CITY OF PORTLAND, MAINE

HISTORIC PRESERVATION BOARD

January 17, 2013

Re: Hotel/Condominium Construction; 321 Commercial Street

BUILDING ELEVATIONS

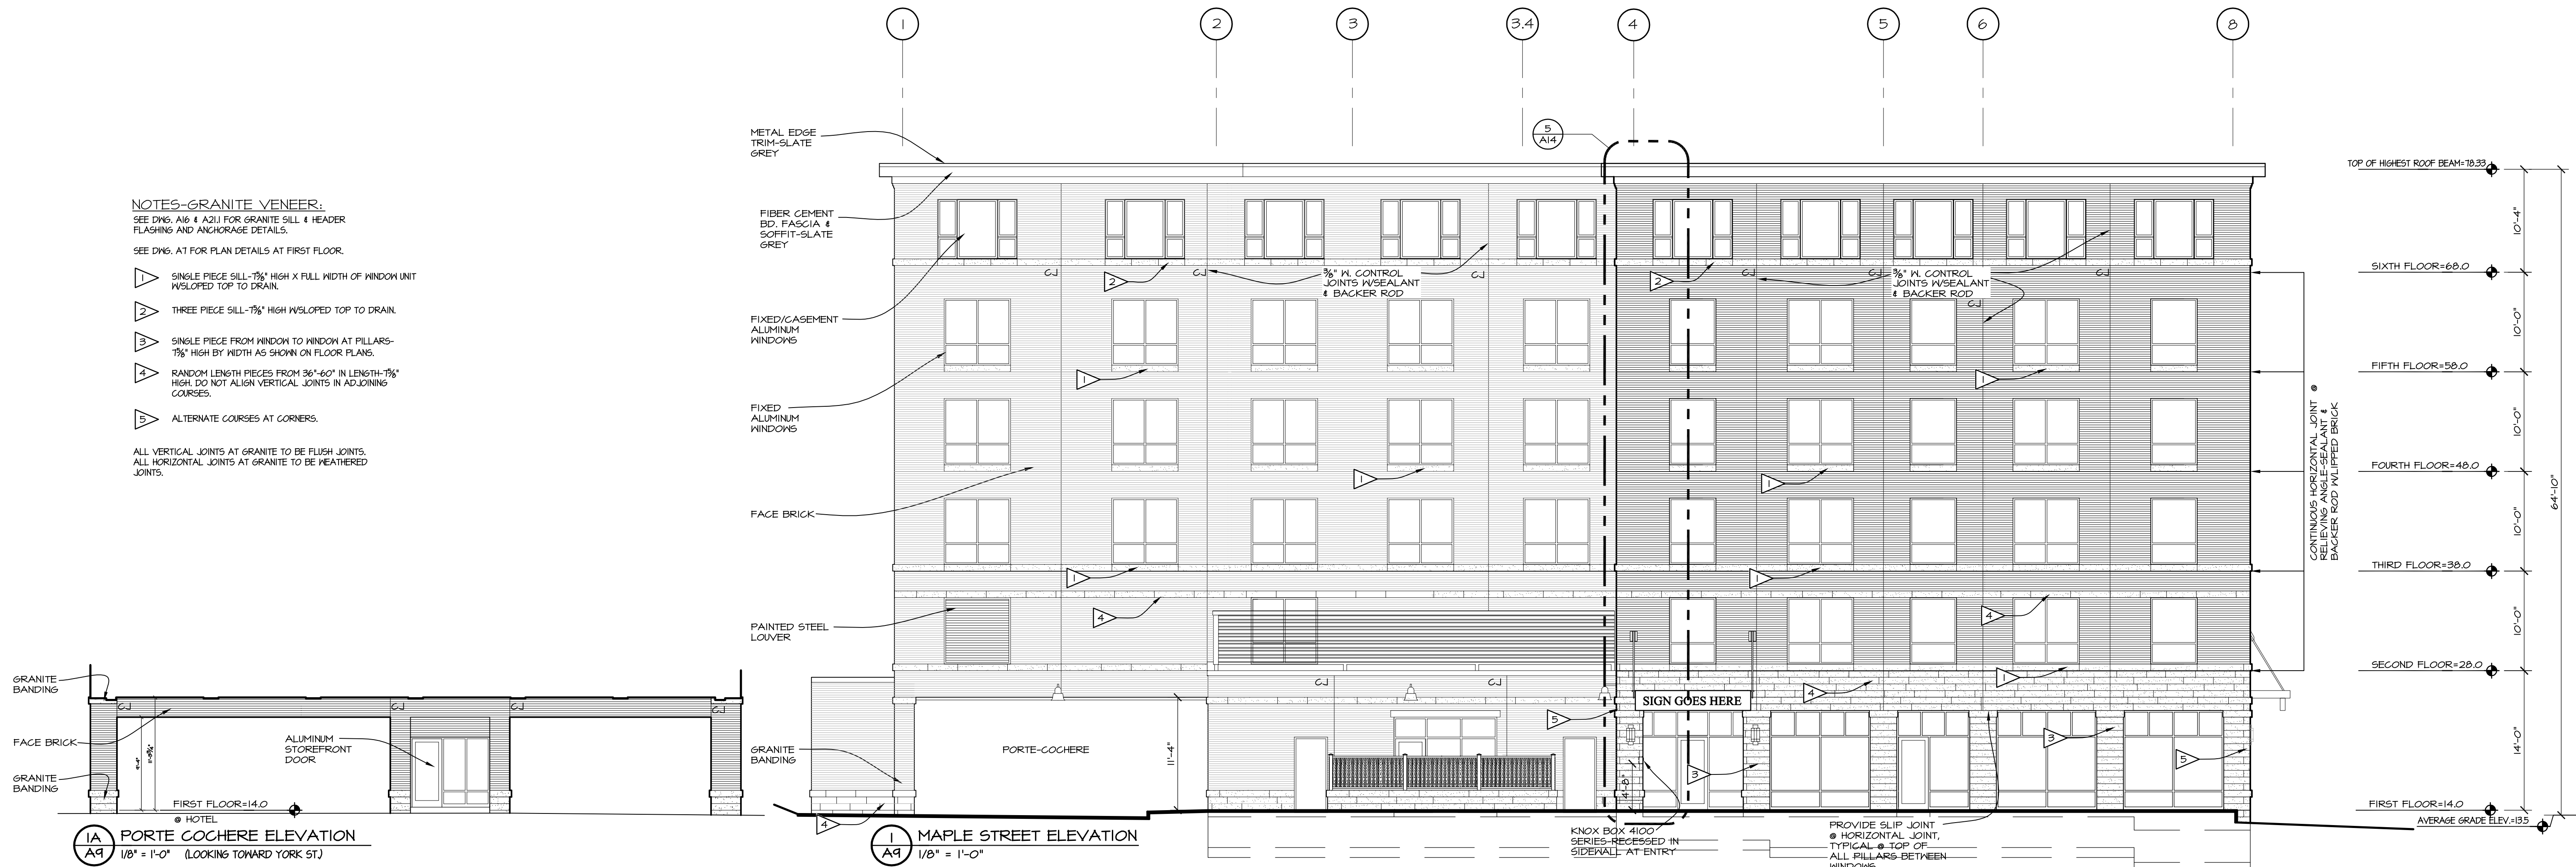
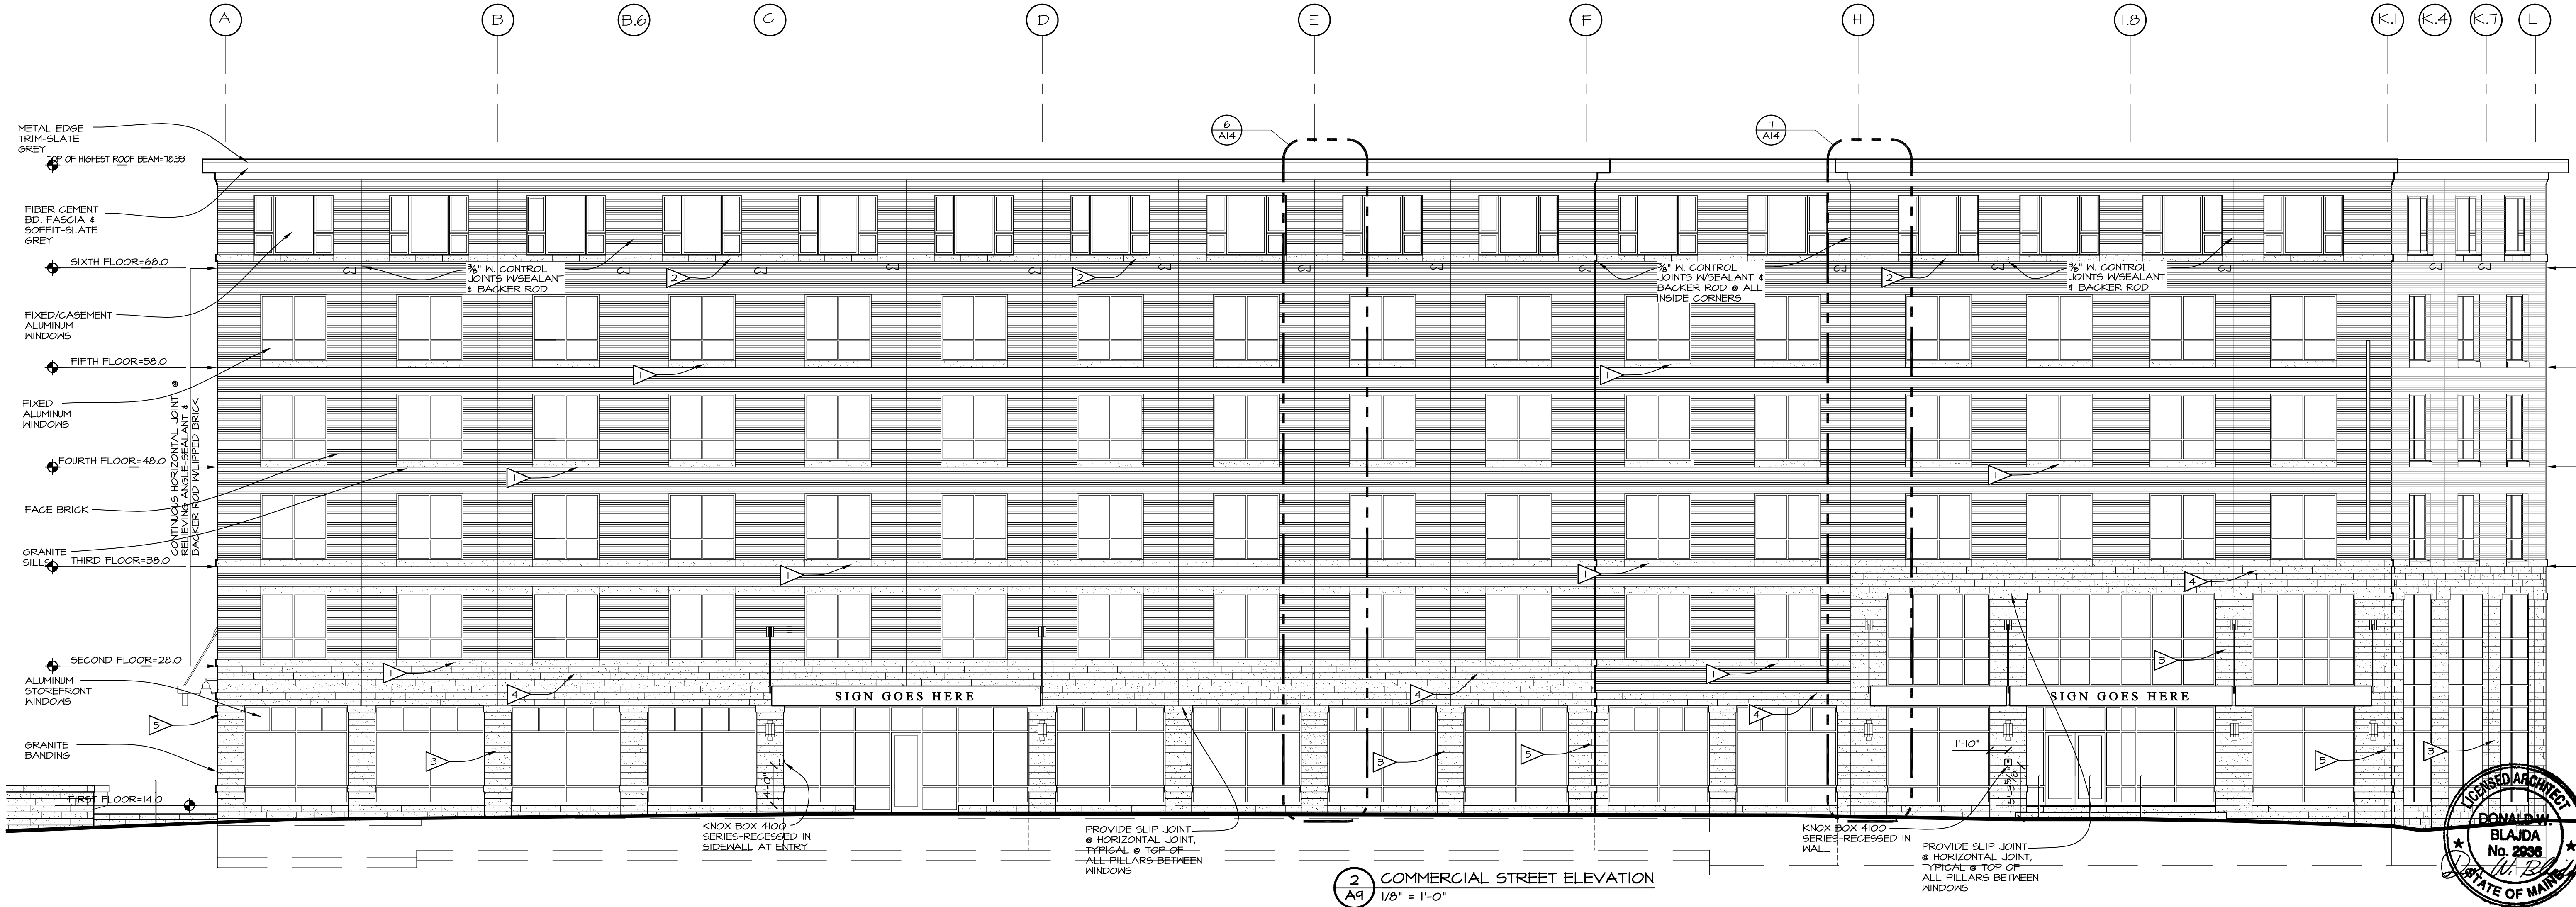
1. The final position of the projecting sign at the corner of Commercial and Foundry Lane to be reviewed and approved by staff. (The Board requested that it be lowered.)
2. Cornice detail to be modified to include a transitional element under the soffit. This transitional element to consist of at least 2 projecting courses of brick and a fiber cement frieze or bed mould. Final detail to be reviewed and approved by staff.
3. To the extent feasible, the framing width of the windows at the top floor of the building shall more closely match that of the lower story windows. (Elevations indicated that the top story frames would be twice the width of the lower story windows.)
4. Any unintentional details still included on the elevations to be removed prior to submitting a building permit application (e.g. façade lighting fixtures).
